**Permit Number: BCOM2505-0003**

**Description: 40 x 60 Multi Purpose Building**

**Site Address: 135 DRY CREEK RD**

**Owner: GREATER VISION FELLOWSHIP INC**

C1.0

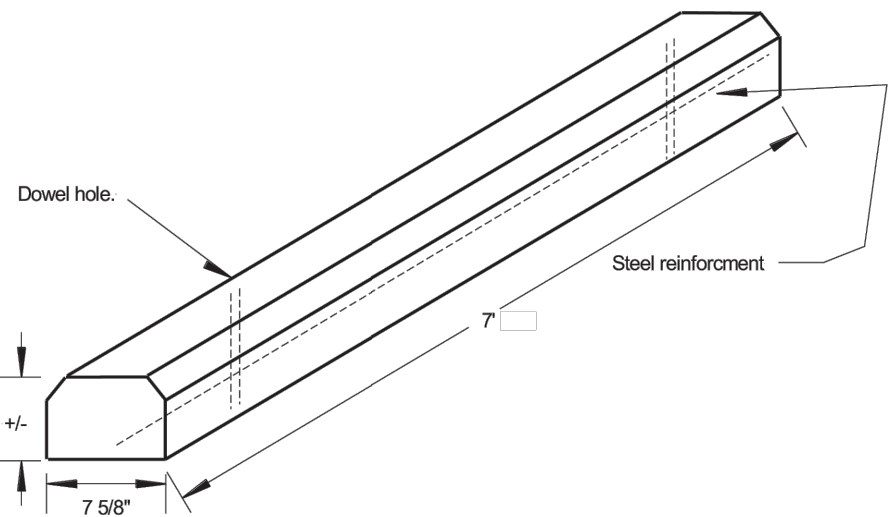
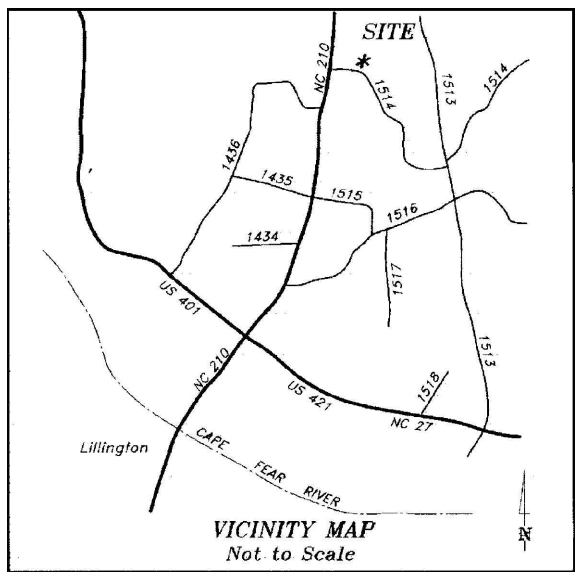
SENT DATE	RETURNED DATE	DUE DATE	TYPE	CONTACT	STATUS	REMARKS
Review Group: ALL						
5/16/2025	5/16/2025	5/16/2025	COMMERCIAL INTAKE	Donna Johnson	NO REVIEW NEEDED	SITE2504-0003
Notes:						
5/16/2025		6/2/2025	ENVIRONMENTAL	EH Bucket		
Notes:						
Please call Mr. Terry before going out.						
Review Group: AUTO						
5/9/2025	5/16/2025	5/16/2025	COMMERCIAL INTAKE	CP Bucket	APPROVED	
Notes:						
5/9/2025		5/23/2025	COMMERCIAL BUILDING REVIEW	Building Bucket		
Notes:						
5/9/2025	5/15/2025	5/23/2025	FIRE MARSHAL	Leslie Jackson	DISAPPROVED	See Notes
Notes:						
<ul style="list-style-type: none"><li>- Appendix B needs to be filled out completely.</li><li>- Need to submit a life safety plan.</li><li>- Need to show at least a 20' all weather access rd. capable of withstanding 75,000.</li><li>- Deed ends 150' of greater will need an approved turnaround installed.</li><li>- Fire hydrant at least 400' from farthest back corner of the building measured by driving distance.</li><li>- Needs to be 150' fire access to all outside portions of the building.</li></ul>
